2022/0878

Erection of single storey side extension to dwelling

12 Hall Farm Drive, Thurnscoe, S63 0JJ

Proposed Site Plan

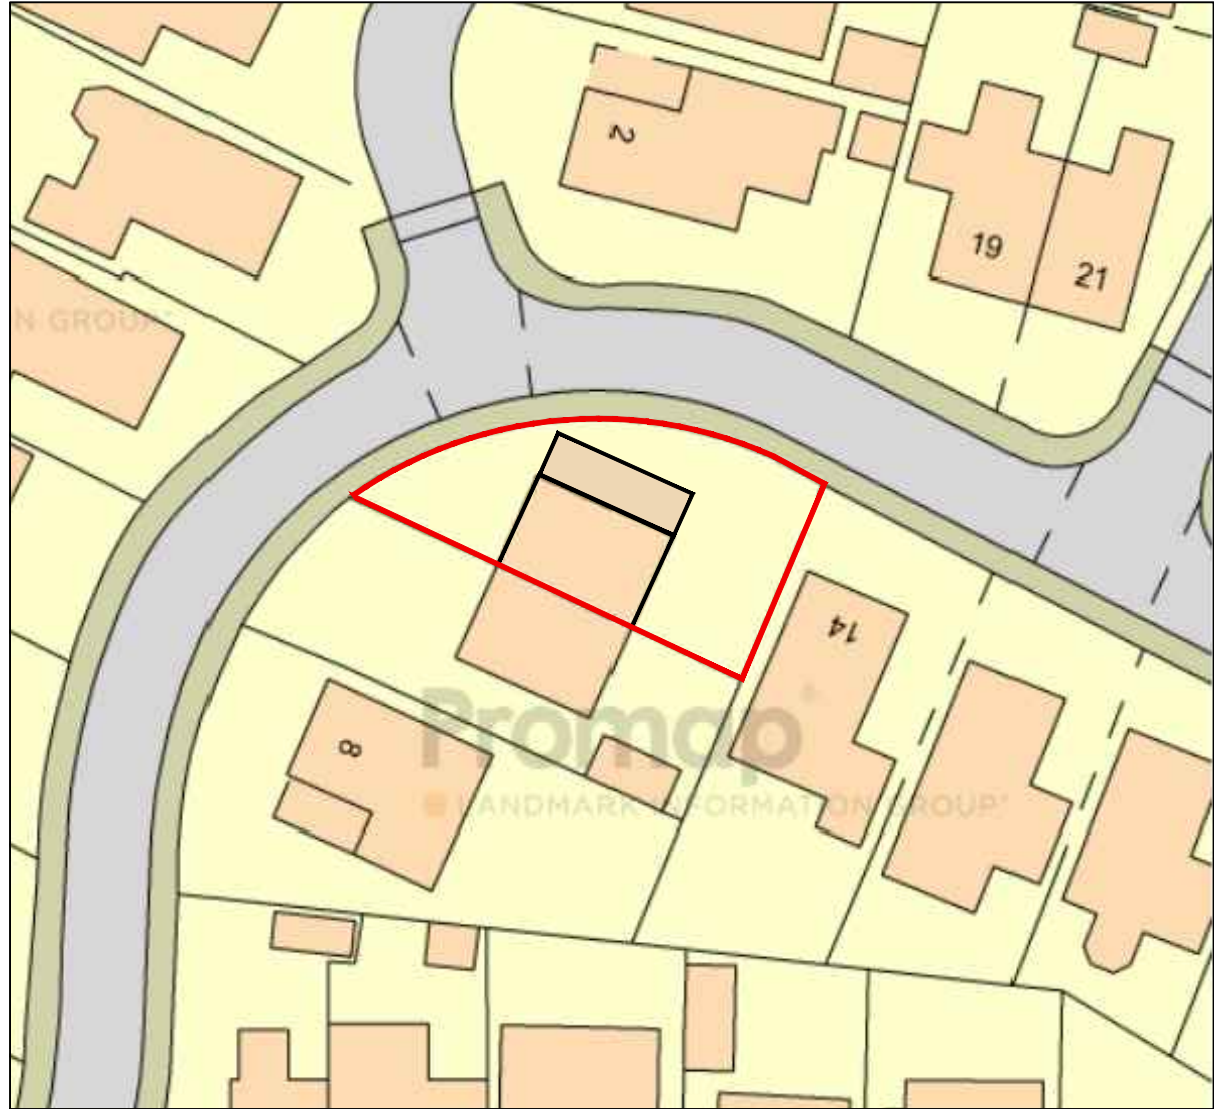
The application proposes to extend the dwelling by increasing the size of the existing bedroom and kitchen, which is unlikely to increase the number of vehicle movements generated by the development. Access to the site will remain as existing. As the existing parking layout will not be encroached upon by the proposed extension and as there will be no additional parking need generated by the development it complies with the parking provision requirements within SPD Parking. The proposed extension to the dwelling will therefore be unlikely to impact upon highway safety or the local highway network in line with Local Plan Policy.

A	19/10/22	AN	225mm stagger added to front elevation and drop in roof line included.
REV	DATE	BY	AMENDMENTS
Planning			
DATE: 17/06/22		SCALE @ A3: As indicated	DRAWN BY: AN
DWG TITLE: Proposed Plans			
DRWG No: 83/002			REV: A

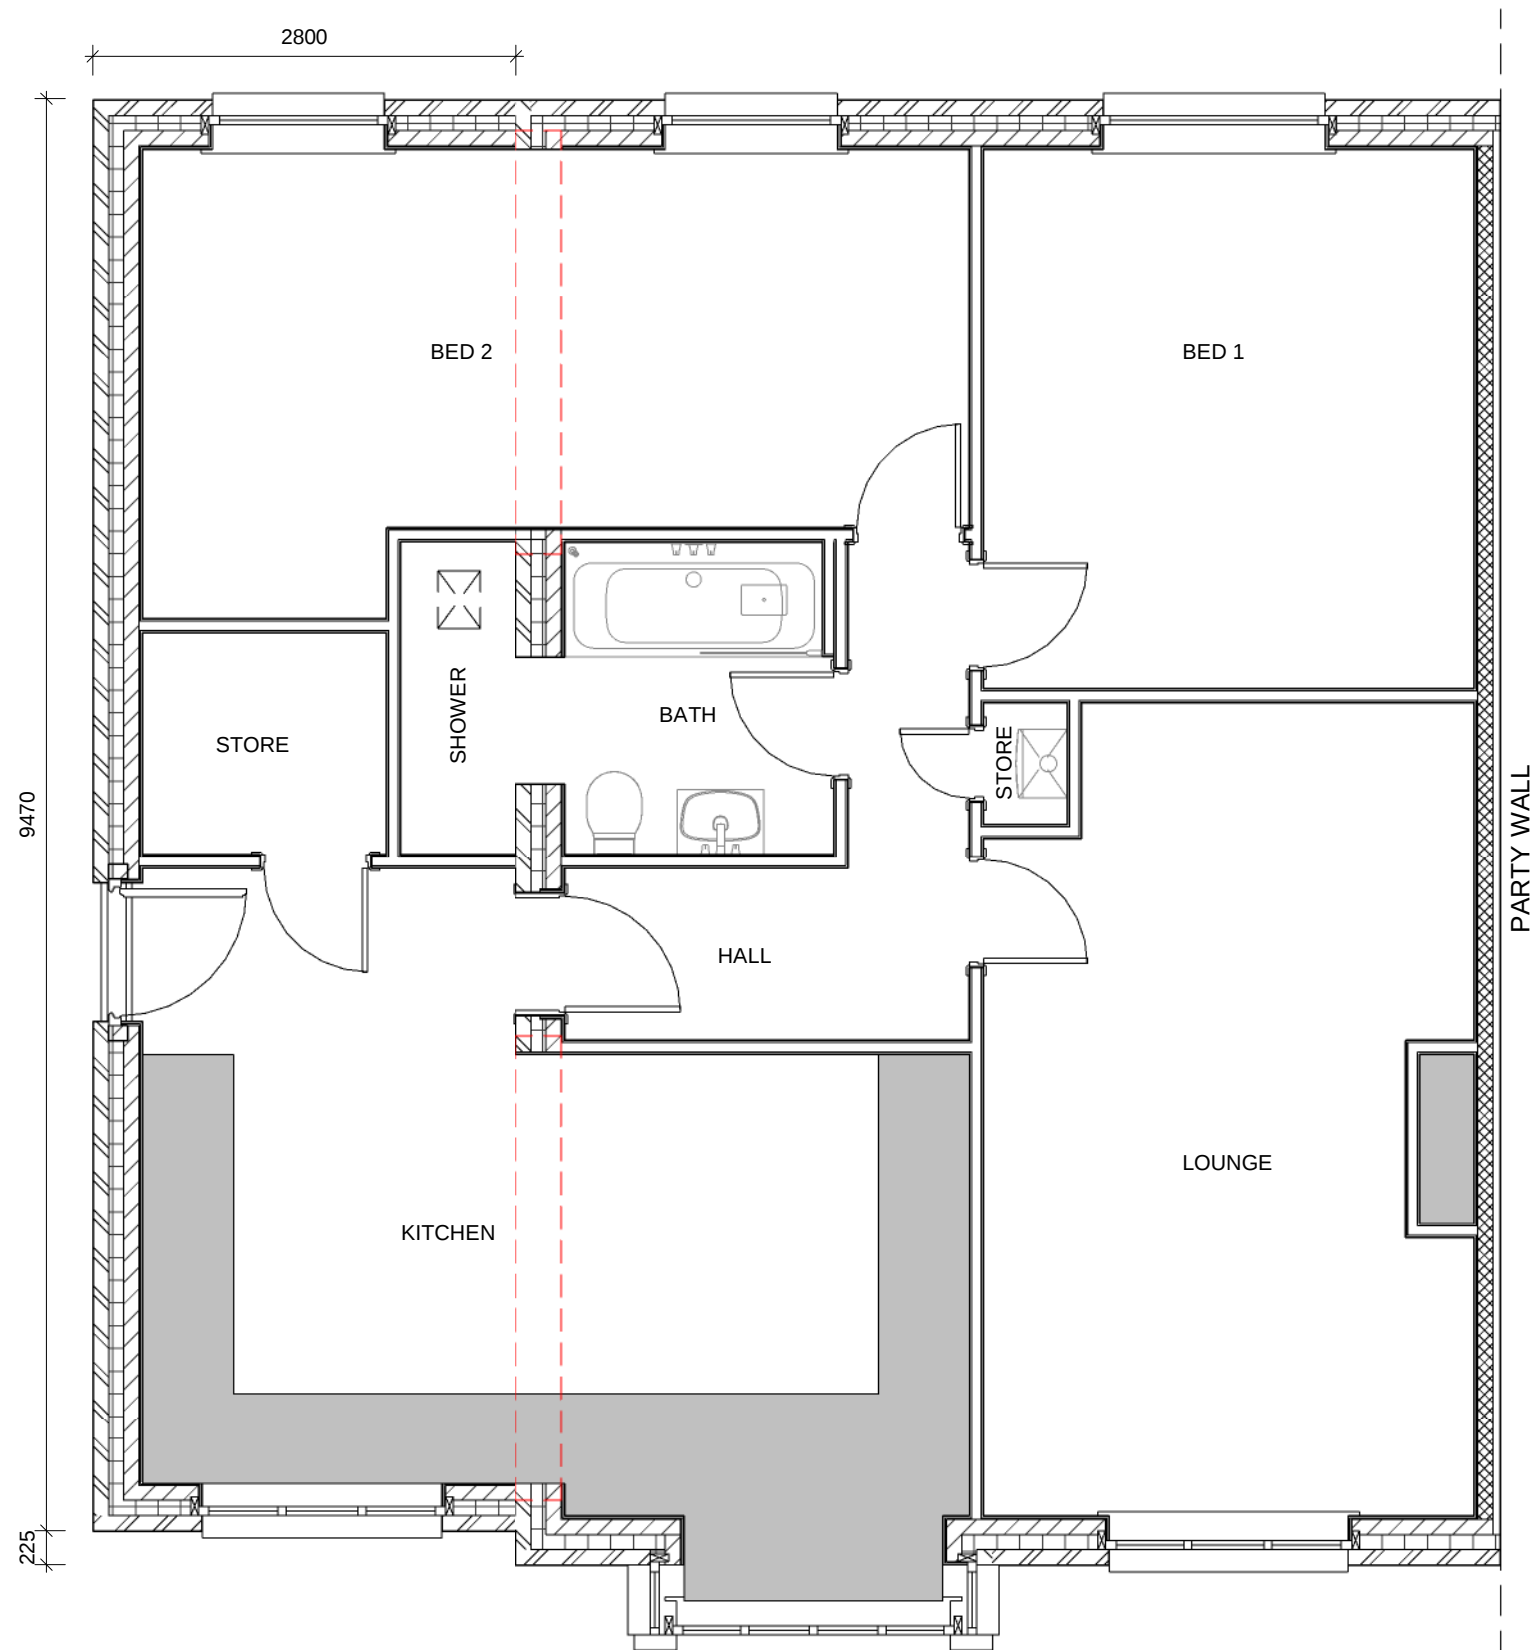
SPD: House Extensions and Other Domestic Alterations states that on corner plots the sideways projection shouldn't exceed more than $\frac{1}{2}$ of the width of the existing gap between the original property and side boundary. This will work towards lessening the impact in terms of the street scene. The side projection has been reduced to comply with this policy, and although the proposal will project further than the existing properties to the rear, when assessed taking in both street scenes impacted, it is not deemed significant enough to warrant refusal.

The side extension has been designed with a pitched roof to match the existing, and in compliance with planning policy has a set back from the front with a corresponding lowered roof line. The addition is clearly expressed, by means of a vertical break/ set-back, and the original identity of the house is retained resulting in a subordinate addition in line with Planning Policy.
